Please ask for: Ms Iqraa Malik
Email: iqraa.malik@terraquest.co.uk
Telephone: 0121 234 1390
Our Ref: LU/335/21/HH
Your Ref:
Date: 26th October 2021

Application for Planning Permission for Works or Extension to a Dwelling

Development: A garden annex for dependent relatives. The annex will be ancillary to the main accommodation, with the occupants co-existing between the annex and main house.

Location: 14 West Head Littlehampton BN17 6QP

DRAWING TITLE
AMENDED / REV 1
Block Plans

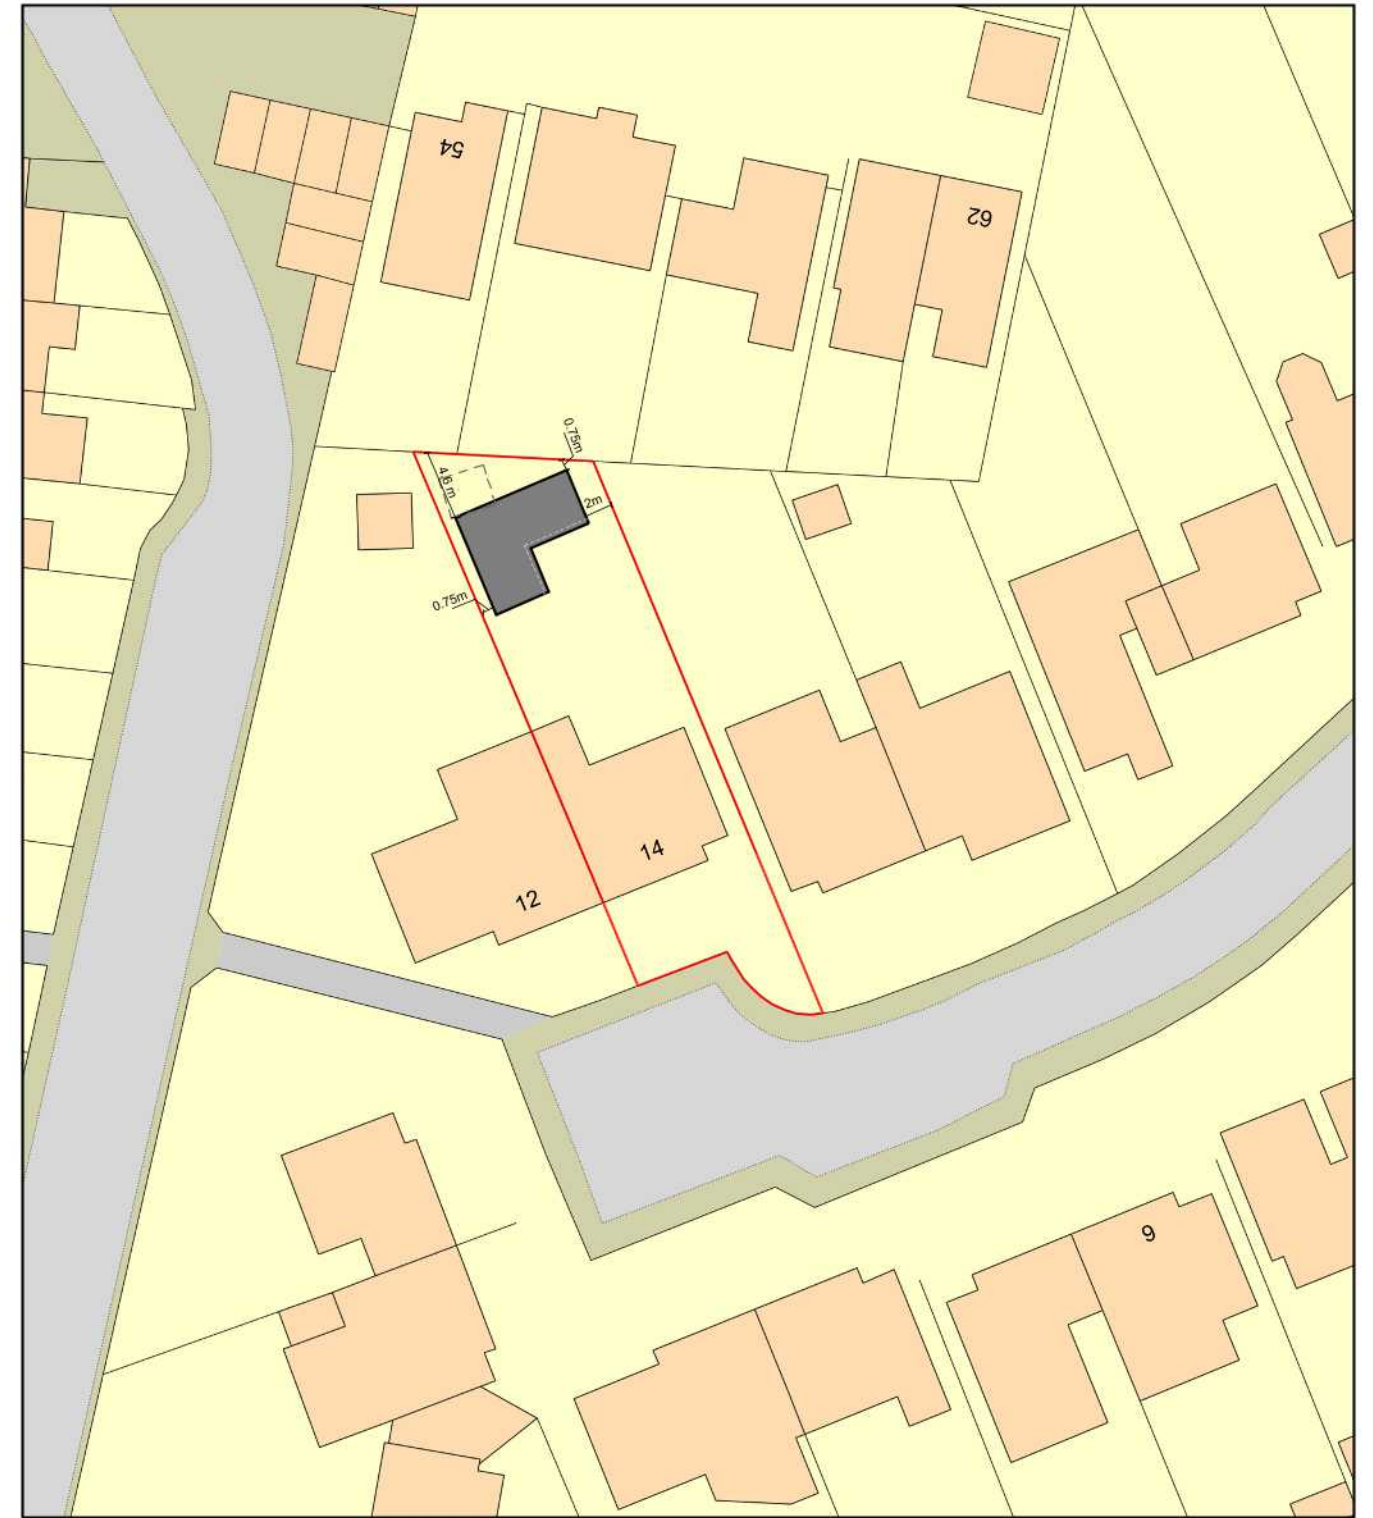
Dimensions: You are required to include dimensions on the block plan from the proposed extension to all site boundaries.
